The Sizewell C Project

**Natural England's Response to Examiner's Questions Part 2**

Planning Inspectorate Reference: EN010012

3<sup>rd</sup> September 2021

DRAWING TITLE:
MAIN DEVELOPMENT SITE
KEY PLAN
RULE 17 REQUEST FOR FURTHER INFORMATION

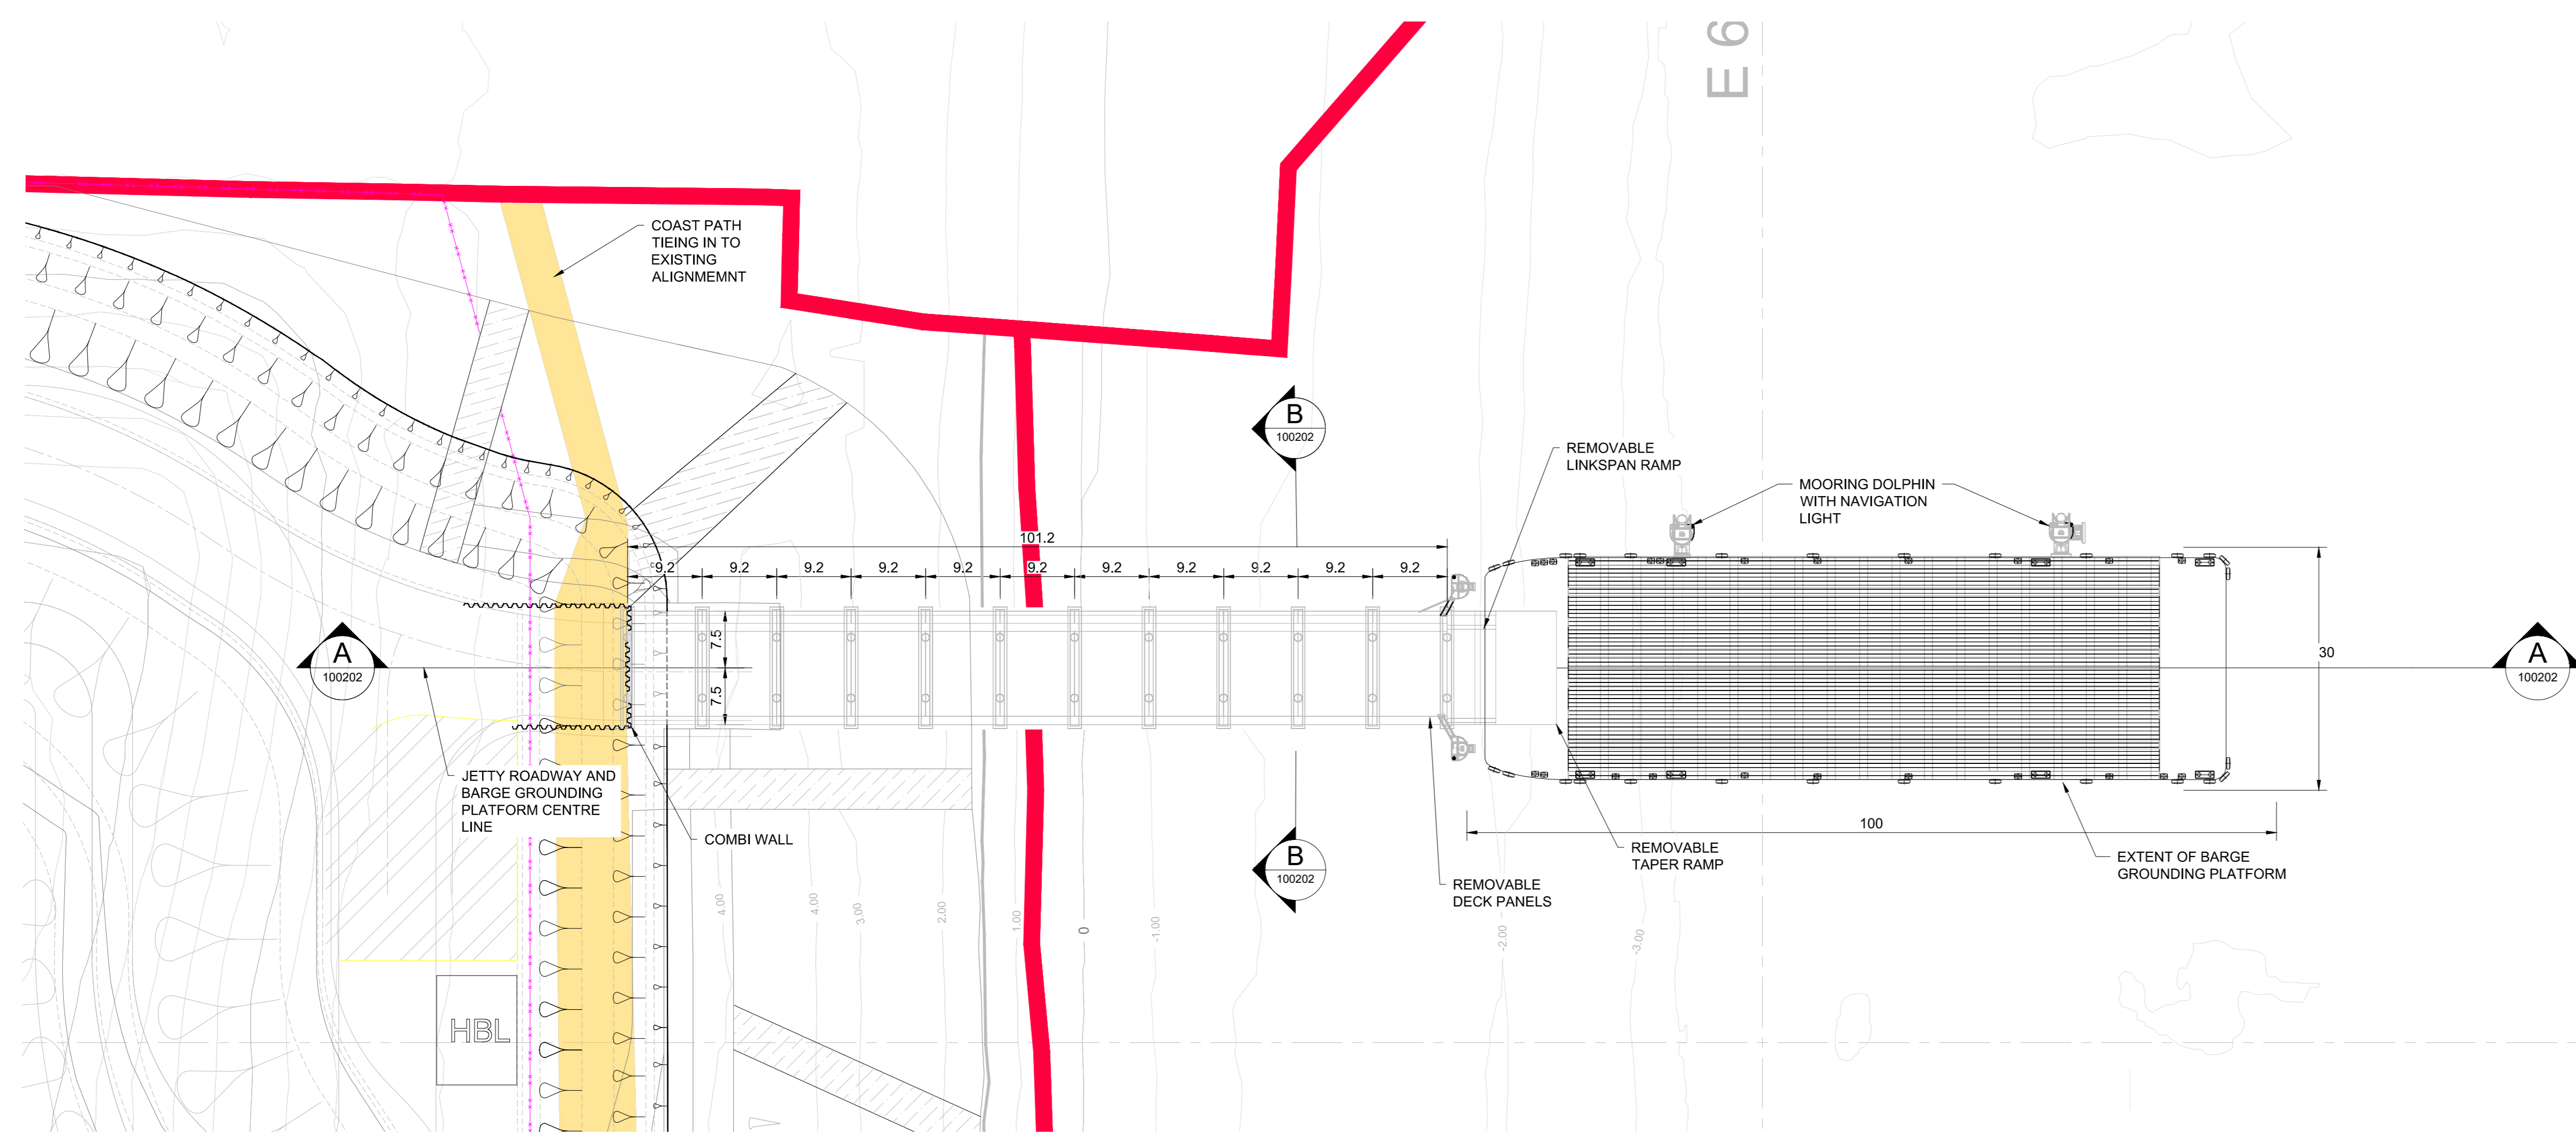
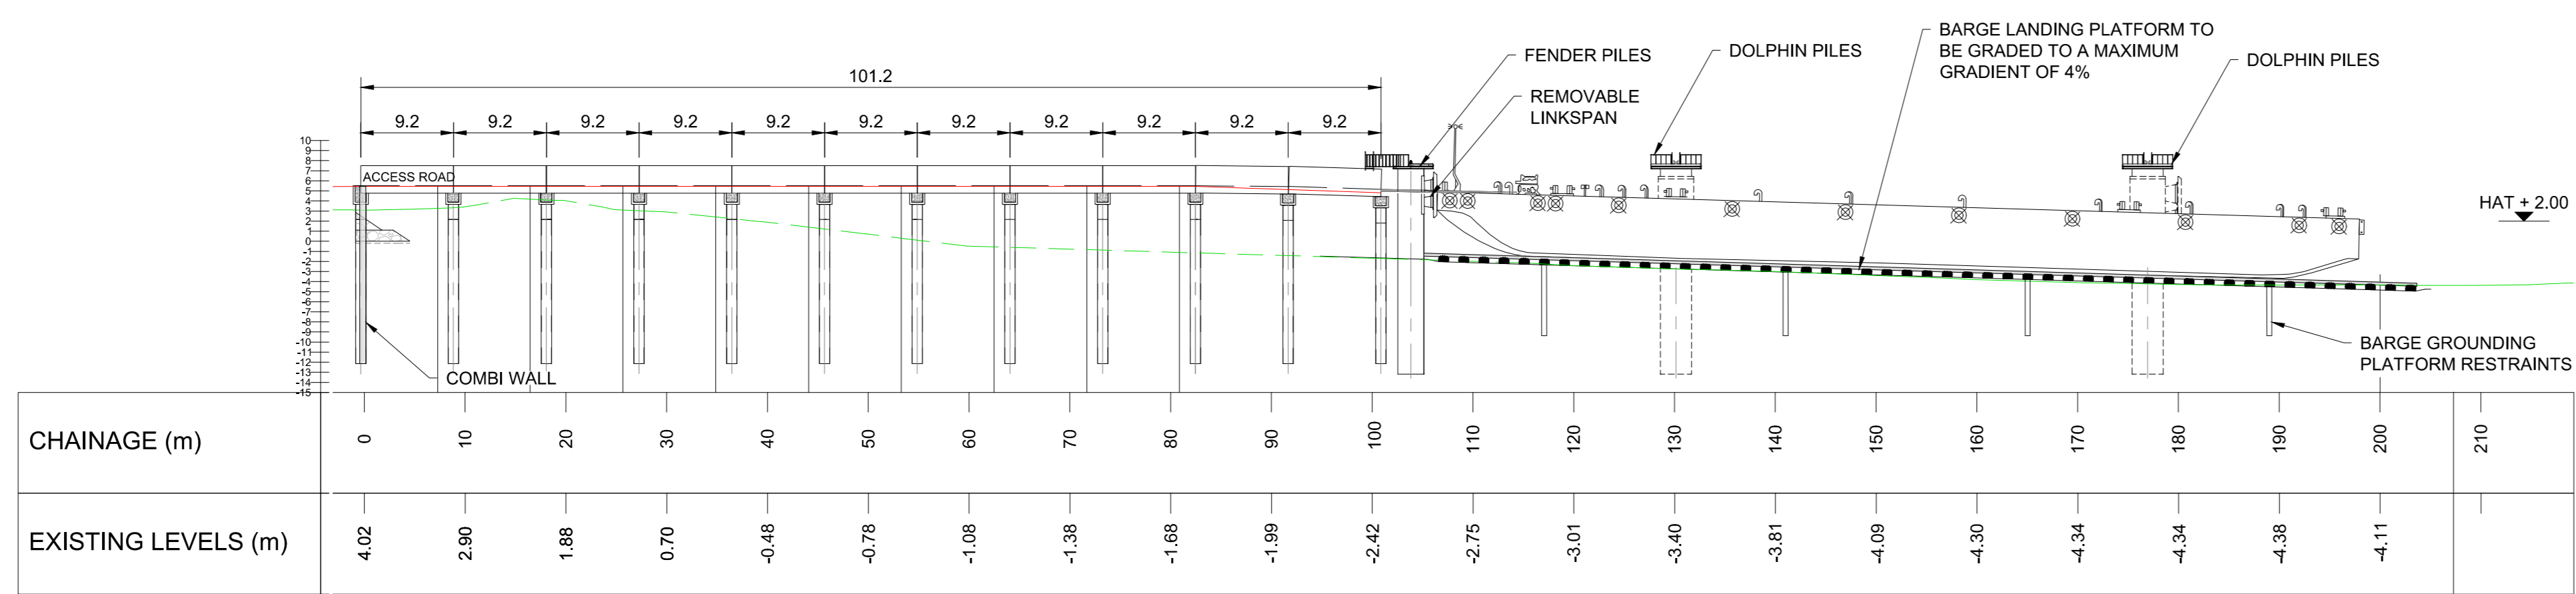
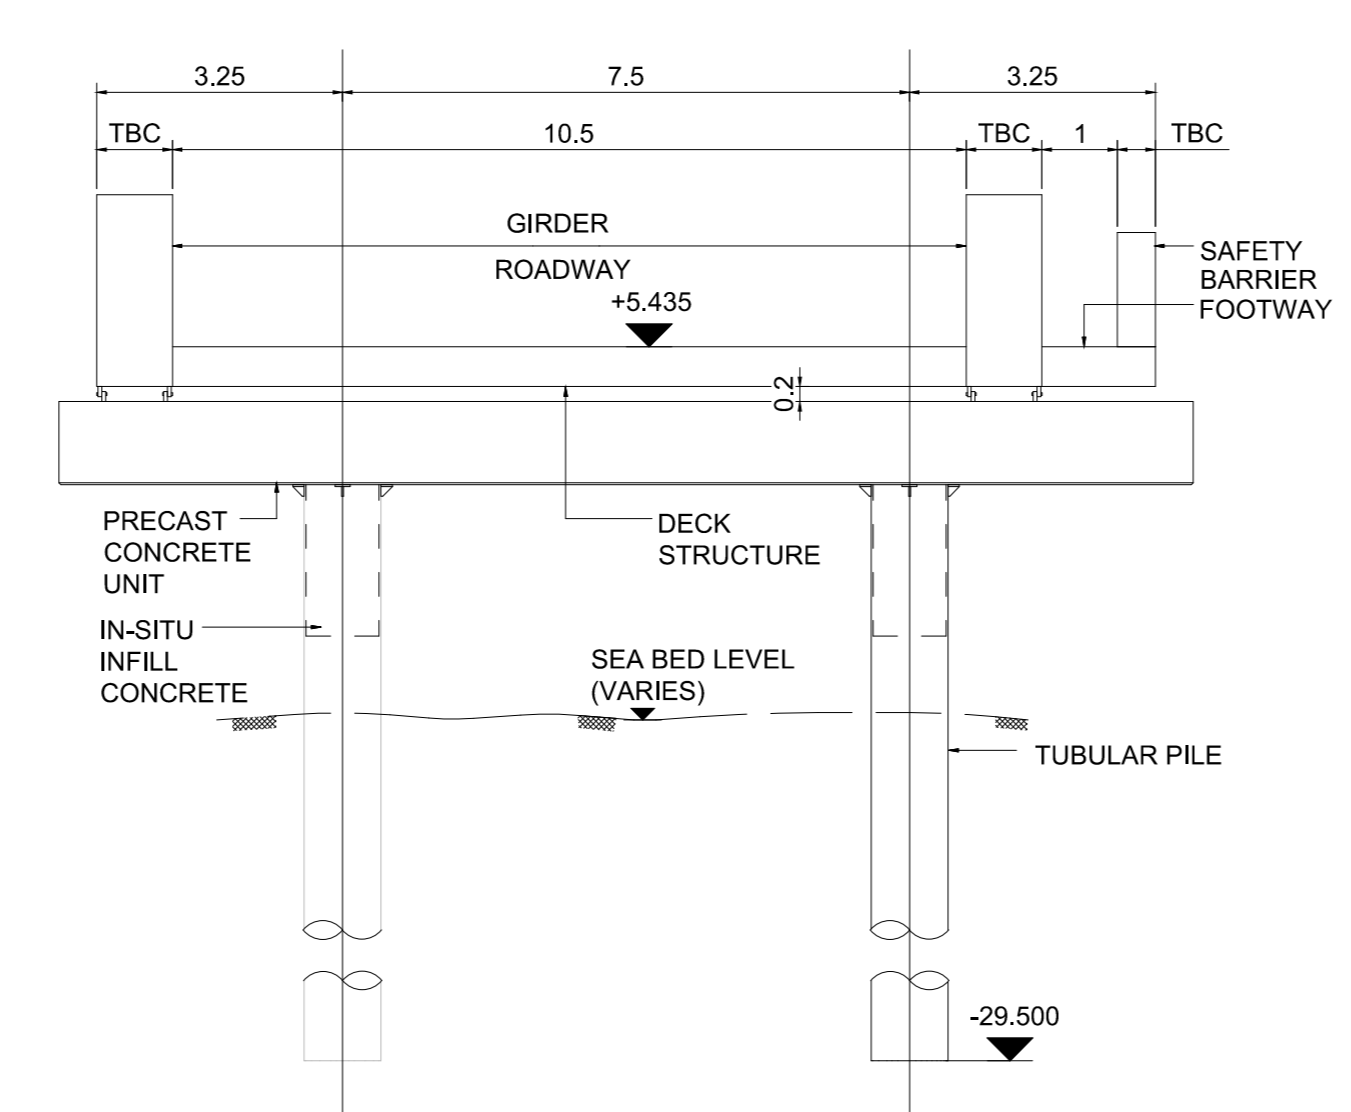
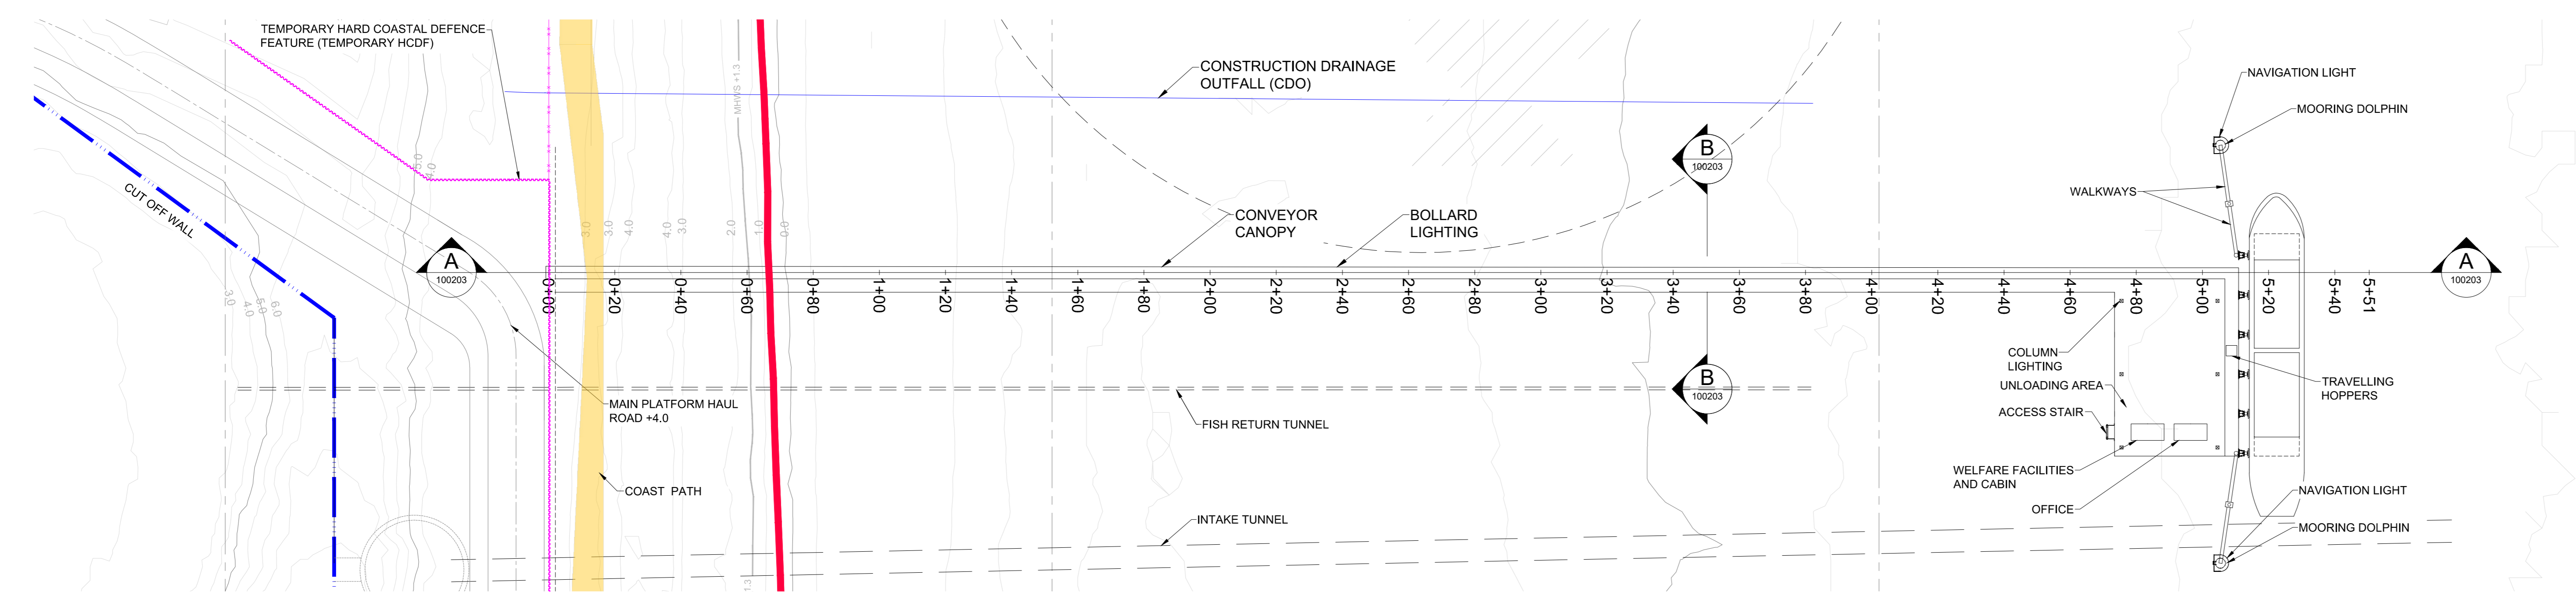
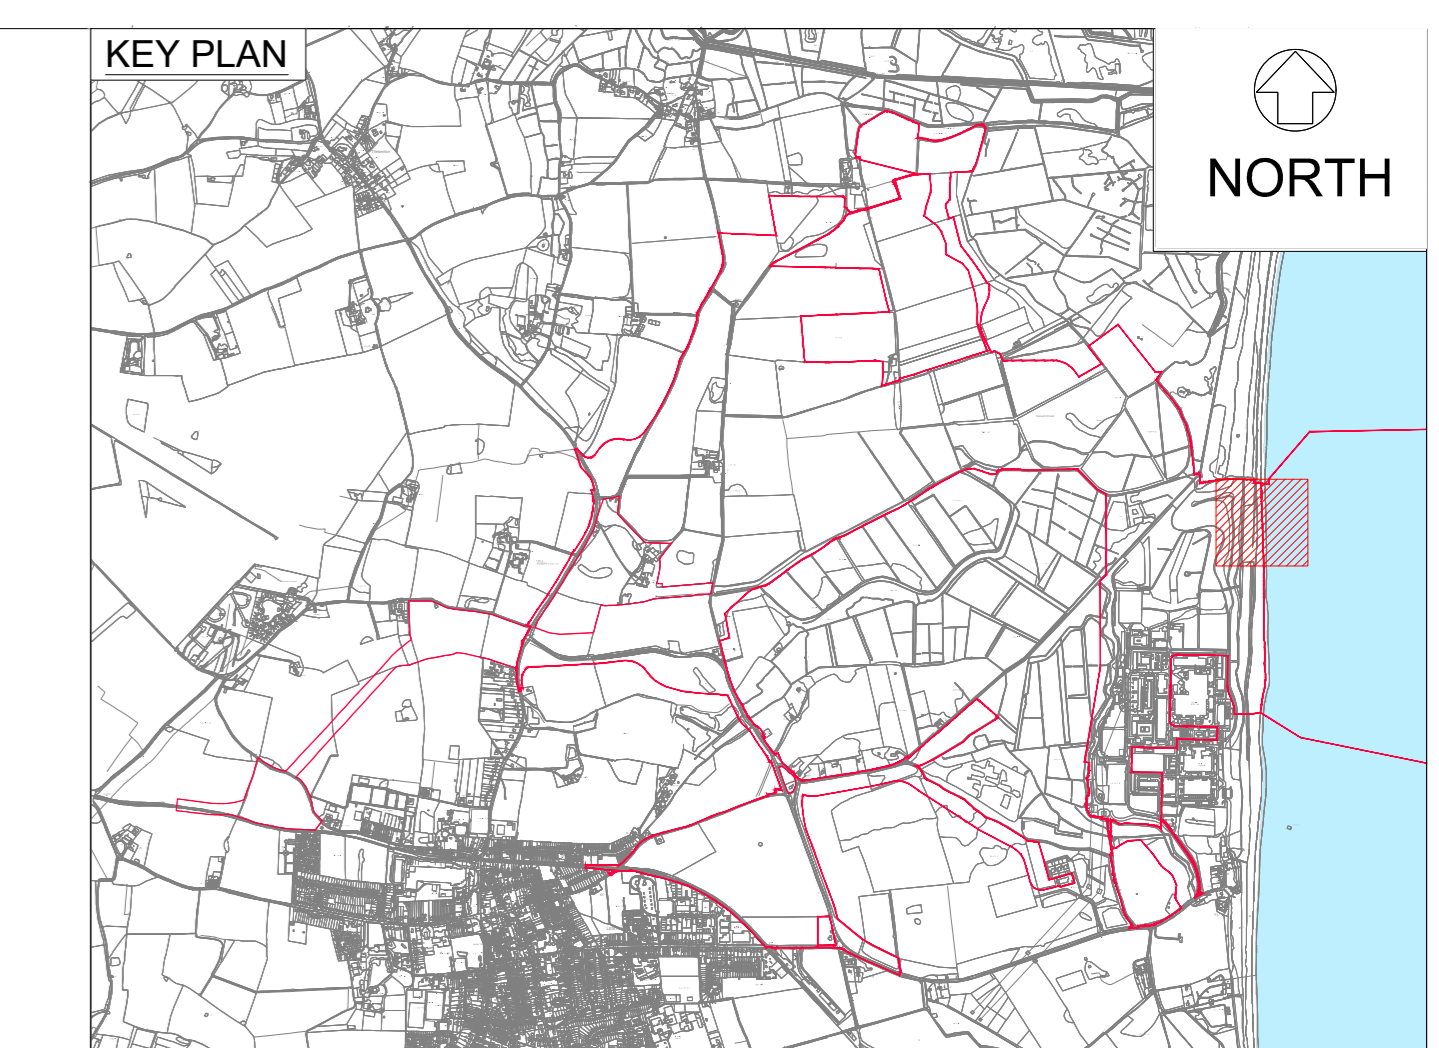
Sizewell C, TASC		<p>However, Natural England still welcomes the optimisation of the hybrid bridge-culvert SSSI crossing design to lessen its impact on invertebrates by raising the soffit height should this design be considered justified by the ExA.</p> <p>As outlined in our relevant representations [RR-0878] <i>“The main mitigation measure if a causeway is constructed is an effective planting scheme on and in proximity to the crossing to maximise how the causeway is screened and blended into the landscape. We note a commitment to plant the margins with trees and shrubs to integrate the crossing into the local landscape and screen / filter views of moving vehicles. That will not compensate for any significant harm which arises to the SSSI, but it may reduce the visual impact of the causeway and its cumulative impact with any visual degradation of the wetland habitat.”</i></p>
LI.2.9	The Applicant, ESC, Natural England, The AONB Partnership, Stop Sizewell C, TASC	Alternative Outage Car Park Note Please review and comment on the content of the SCC submission [REP5-171].	SCC makes a very clear and compelling case for an alternative solution. We support their contention that the proposal for additional outage parking to be sited within the designated landscape of AONB is disproportionate to the anticipated or likely need. This is particularly the case given that SCC have proposed alternative approaches which appear to be both practical and deliverable.
